STEENSEN VARMING

Response to: "Western Façade should have additional external sun shading"

Sydney December 17, 2021

ELEVATION WEST

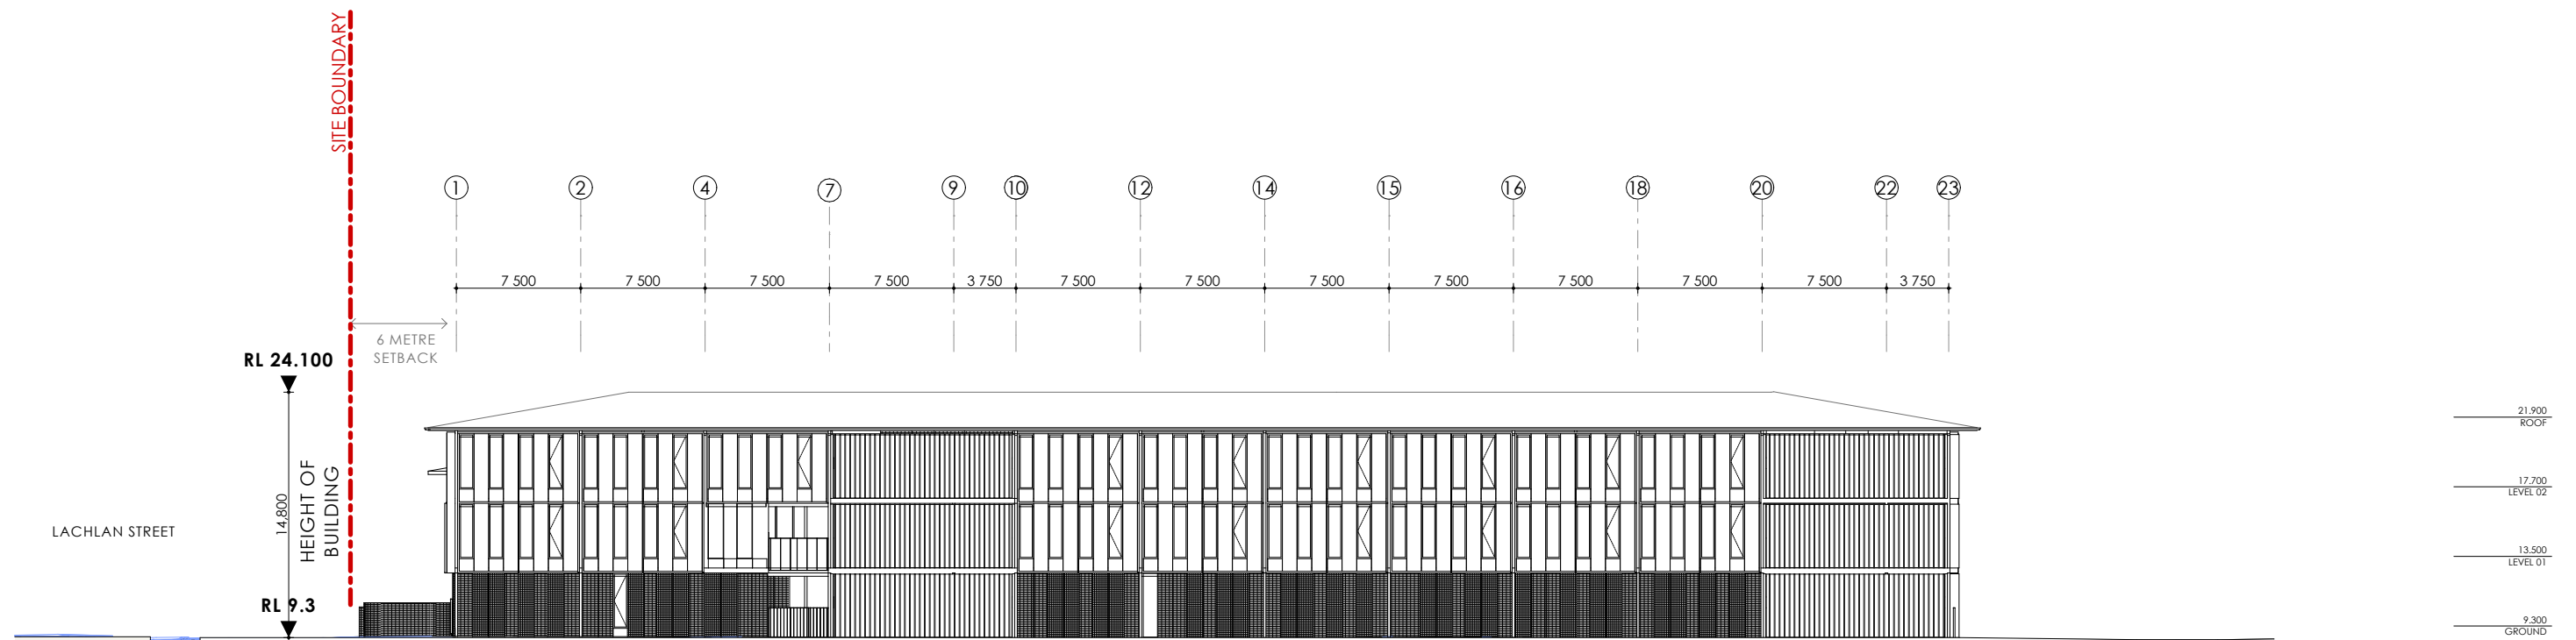
It is acknowledged that the proposed shading on the Western façade could be more effective, however, vertical shading (unless angled and of a reasonable size) will be of limited performance, due to the high extent of changes in the altitude and azimuth of the sun's position.

Large shading devices which would effectively shade the Western façade are likely to compromise good levels of daylight, views, and ventilation. As such, the proposed solution was to:

- 1) Increase the glazing performance on the West from a purely compliant (NCC 2019) SHGC of greater than 0.6, to an SHGC of approx 0.5 (final values to be confirmed)
- 2) To avoid unwanted thermal loads (conduction and solar) and glare concerns, the recommendation for the glazing percentage (window to wall ratio) on the East and West façades, was to be in the order of 25-35%. The initial concept proposed 45%, this has subsequently been reduced to 23%.

Daylight studies have confirmed that with the proposed glazing ratio on the West (23%), the classrooms achieve good levels of daylight (160 lux over 80% of the time in 40% of the nominated areas), as per the EFSG requirements. Sun studies have been undertaken to assess the impact of the sun on the Western façade. When the shading is not effective, blinds will assist for the remaining hours of the school day (up to 15:30).
